**22 PINE GROVE, TOTTERIDGE, N20 8LB**

3.1 Pre-planning Advice

Sub/ZERO architecture have been instructed by the owners of 22 Pine Grove, London N20 8LB to submit a full plans application for the proposed works to their property.

PROPOSED WEST ELEVATION

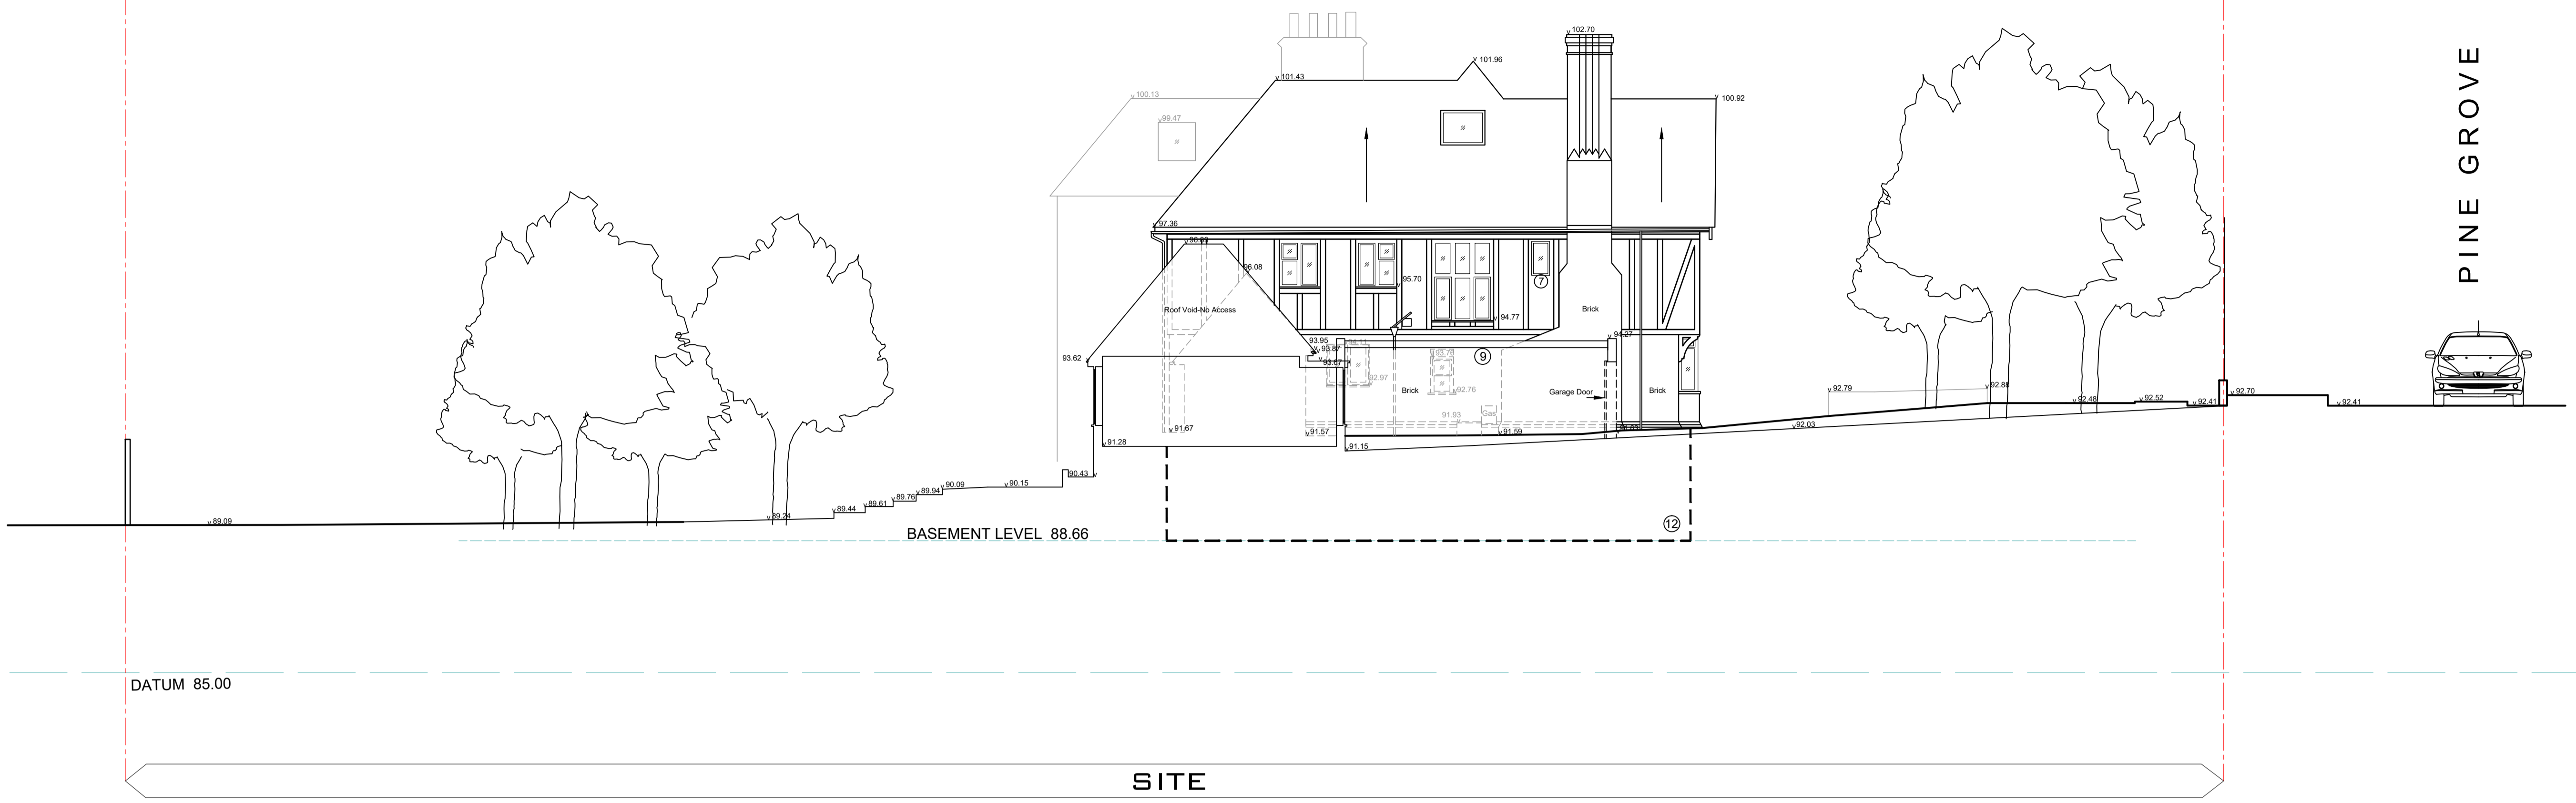
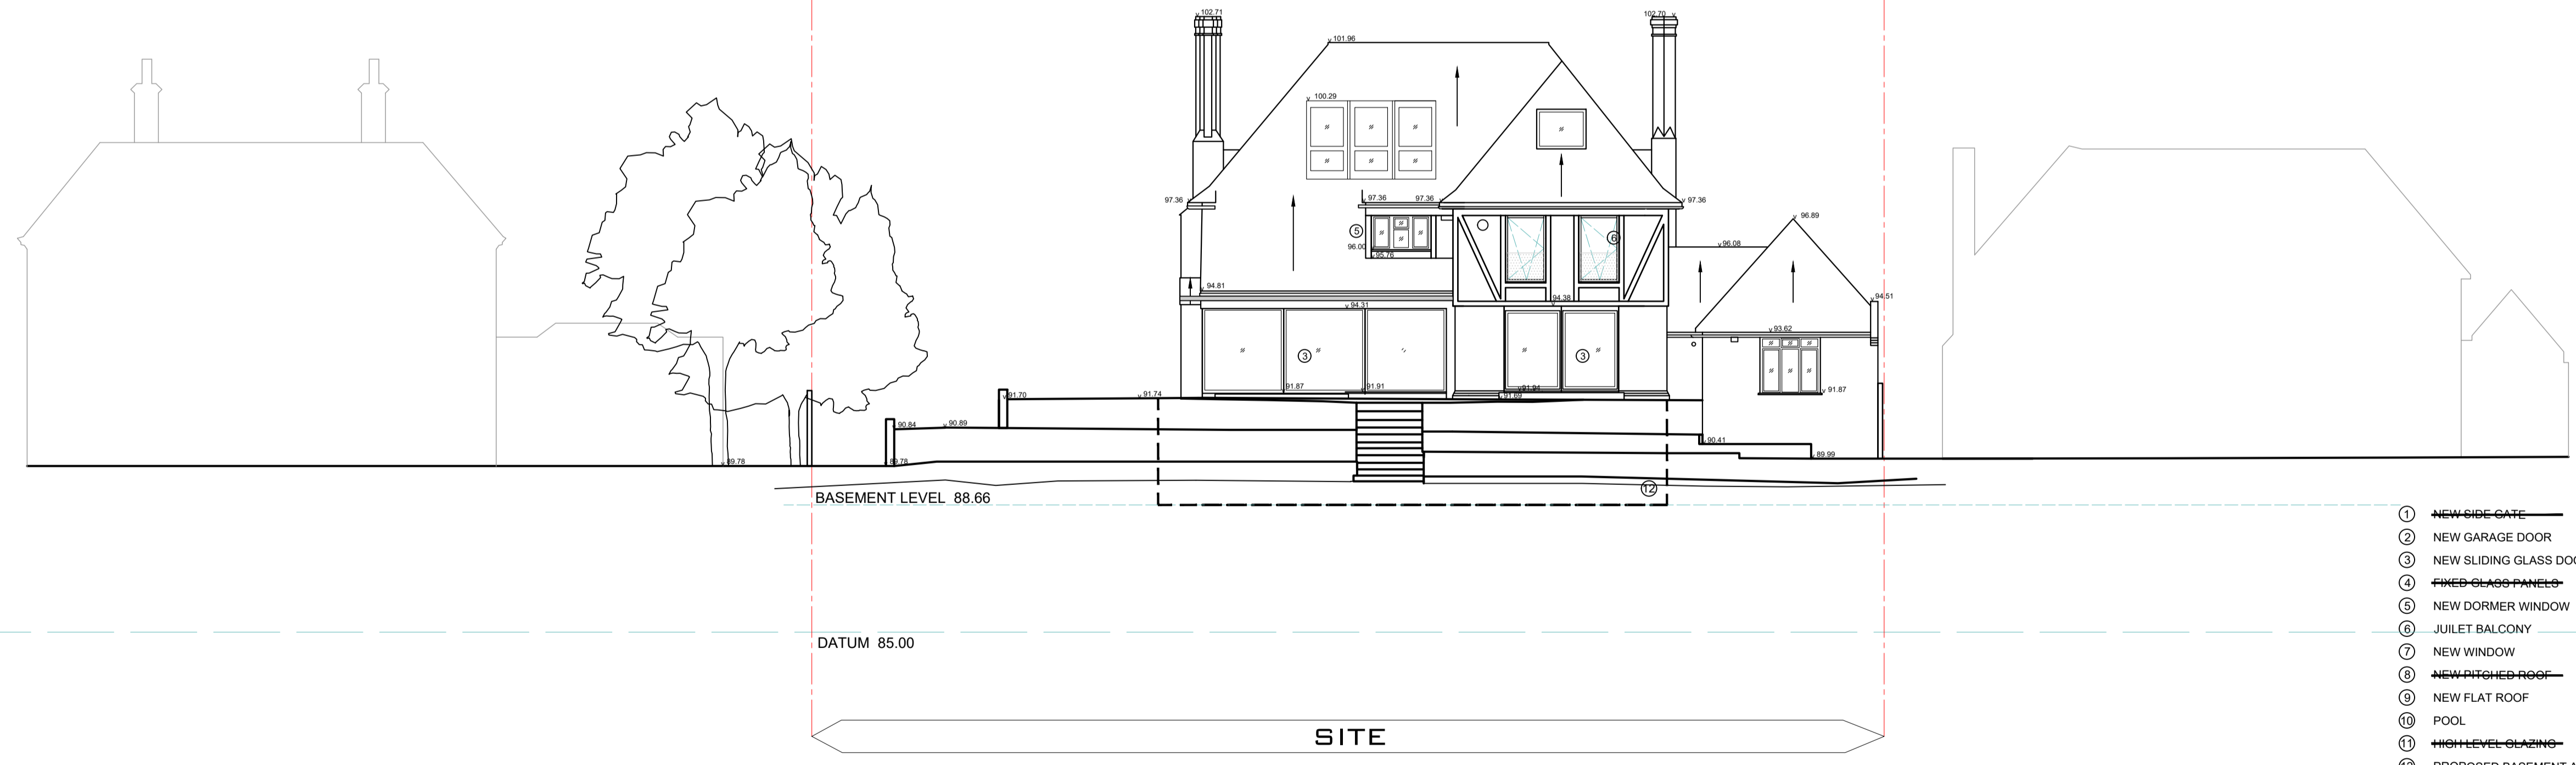
6.33 In addition, a new Juliette balcony is proposed to the window at first floor level. The Juliette balcony will be flush with the rear wall and will not provide a surface to step out onto. Therefore, this balcony on its own is not considered to result in overlooking or loss of privacy to neighbouring properties. However, it is noted that the existing 2no. window will be replaced with 1no. large window, which will not be acceptable. Too Issued in confidence by London Borough of Barnet 9 much glazing can have a negative impact on the character and appearance of the dwelling. Therefore, it is advised that the 2no. windows are retained at the same width, with the proposed height. 2no. separate Juliette windows will be acceptable. Likewise, it is recommended that the new full width window at ground floor will not be acceptable and will need to be retained as 2no. separate windows, to be in keeping with the windows at first floor level.

The proposal has been revised to two Juliette Balconies as per the stated recommendation.

PROPOSED PLAN - Lower Ground Floor **scale 1:100**

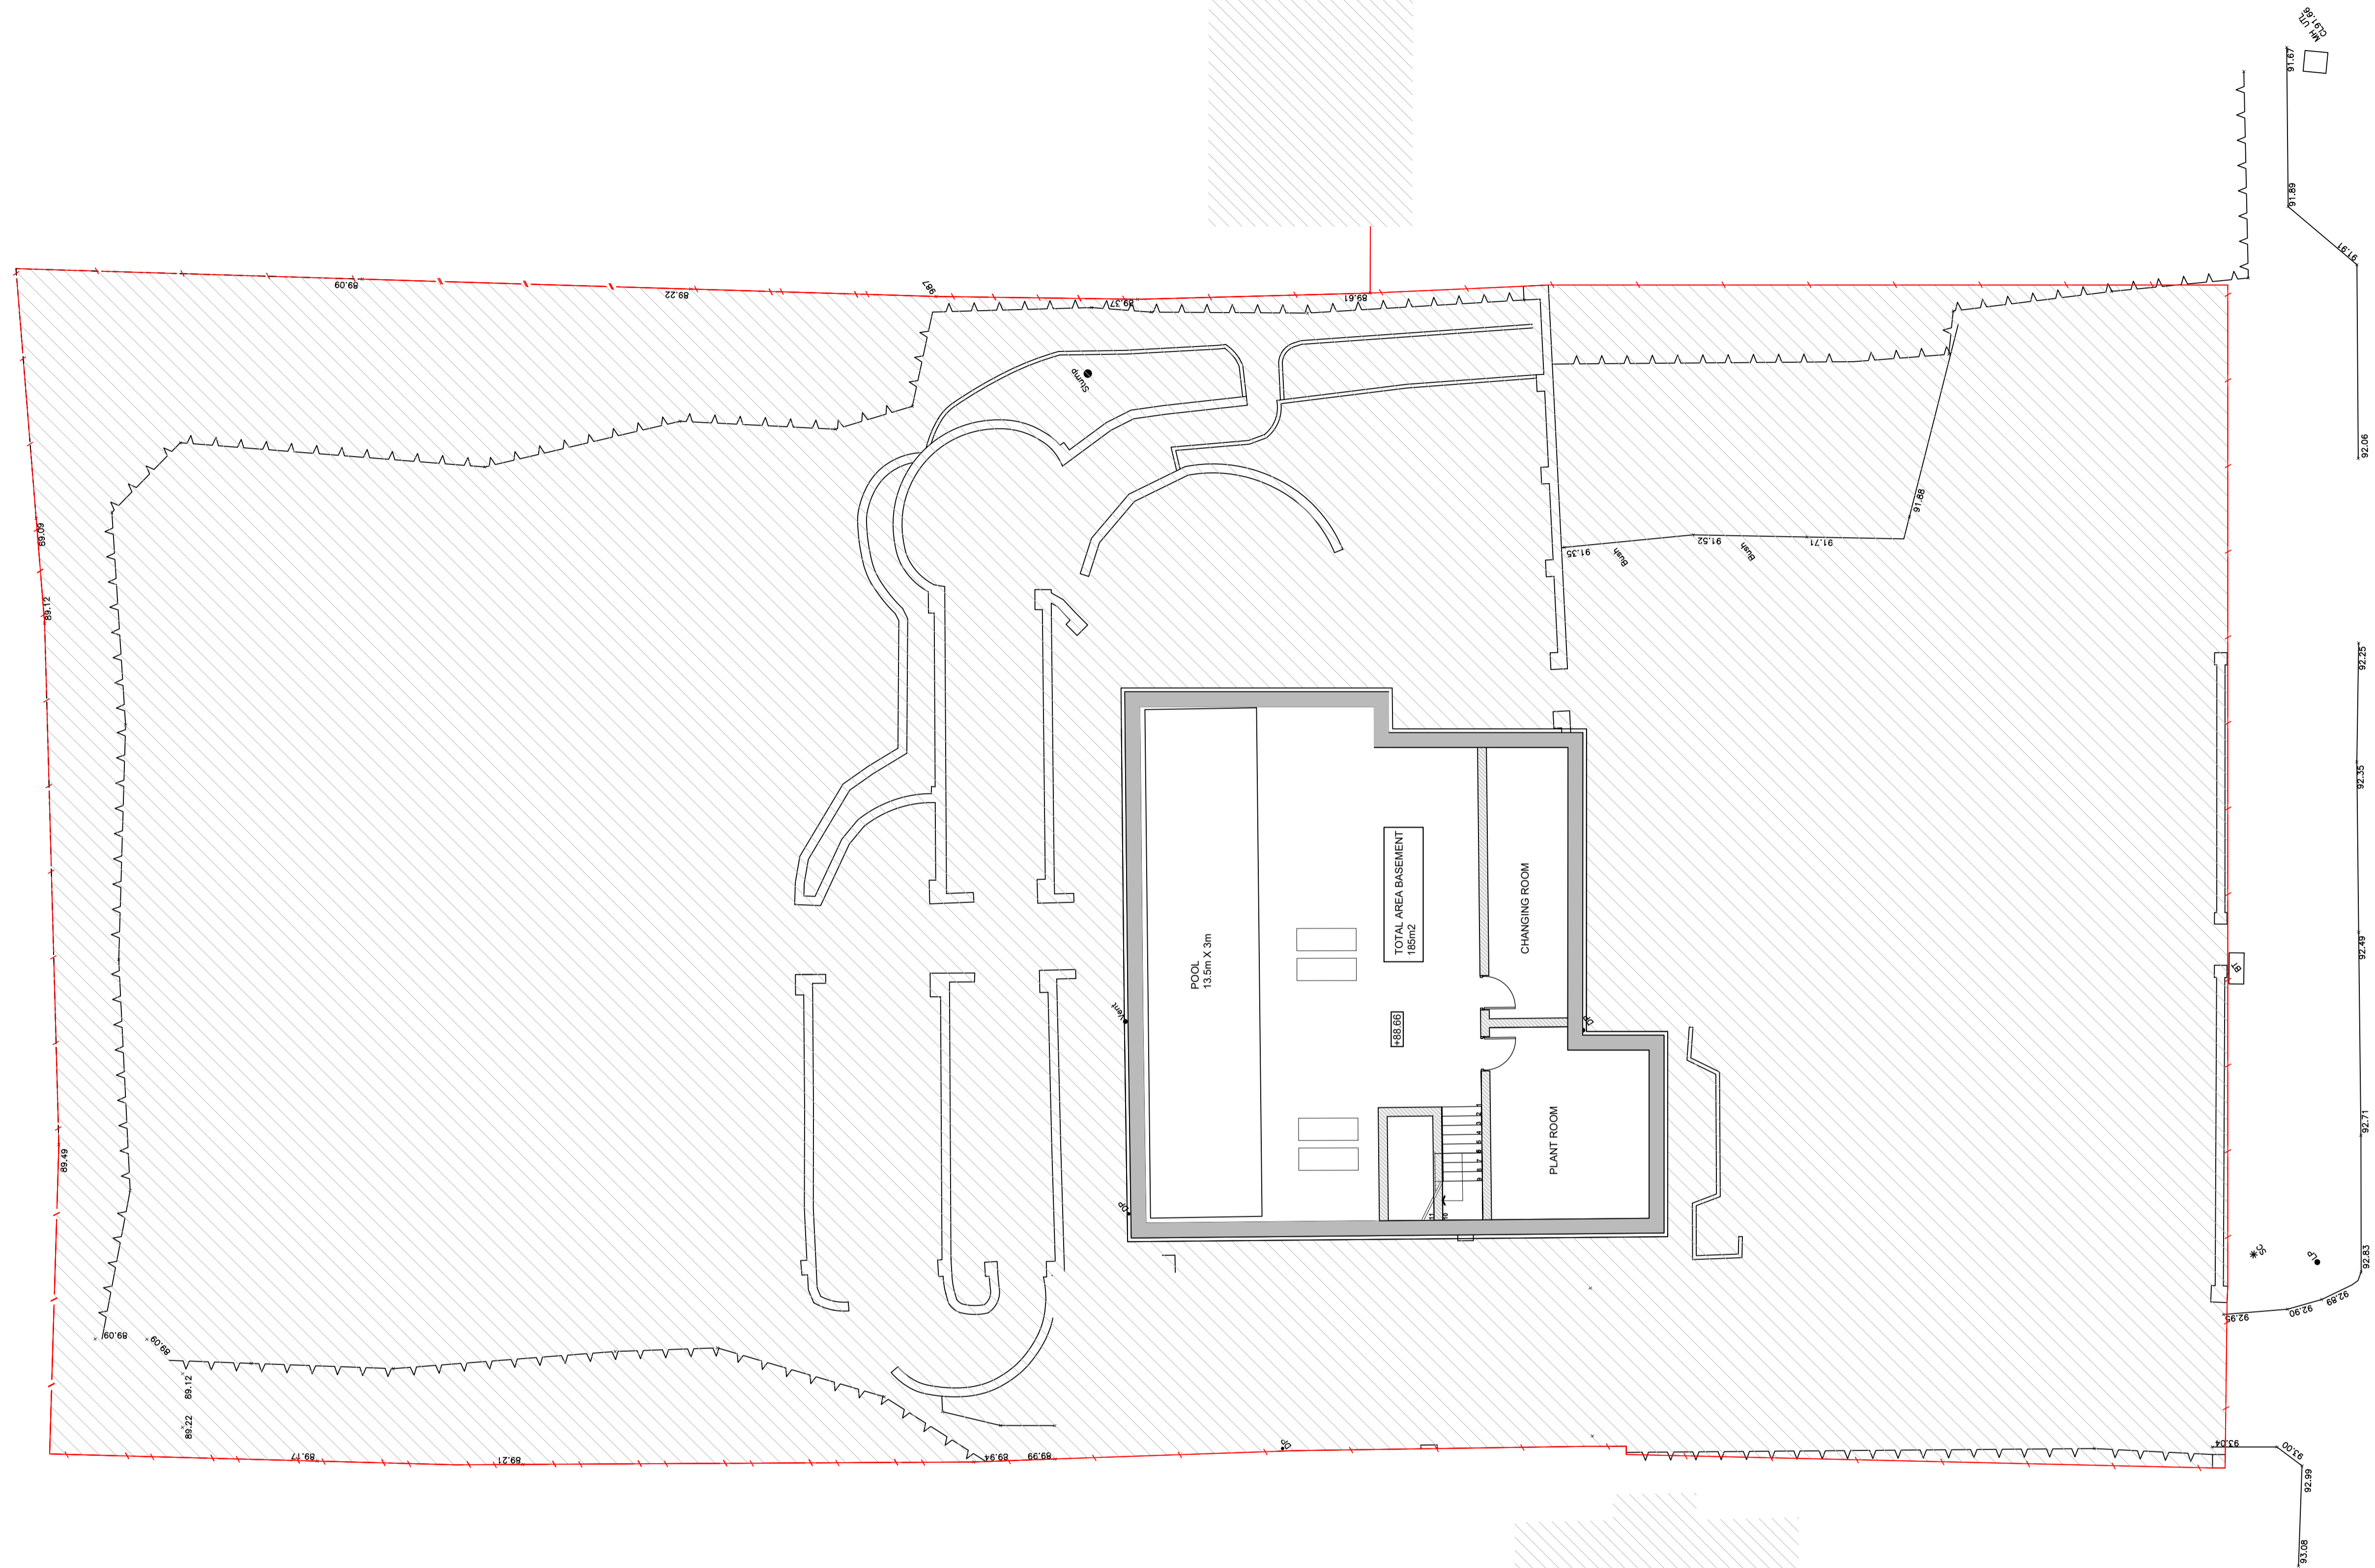
6.24 The basement (option 1) appears to extend over 3m beyond the rear and front elevation, combined with the sunken terrace, as proposed, would appear to be extensive. It is recommended that the basement is reduced in depth, not to extend beyond the front elevation of the existing dwelling and not to extend over 3m beyond the rear elevation of the existing side extension. It is recommended that the basement as much as possible is contained within the footprint of the existing dwelling.

6.27 The basement (option 2) involves creating a basement under the rear patio and will occupy most of the width of the rear patio. Elevations have not been provided, but the assumption is that the ground will be excavated, and the rear wall of the basement will be visible from the rear garden. The sheer scale of the lower ground floor would appear as an unduly bulky and visually prominent extension to the property and is considered to detract from the established character and appearance of the dwelling. Whilst a basement would not be opposed in principle, the size of the basement and the visual manifestation should be considerably reduced to be acceptable.

No longer applicable as the new proposed basement takes the shape of the building’s footprint.

No longer applicable as the new proposed basement takes the shape of the building's footprint.
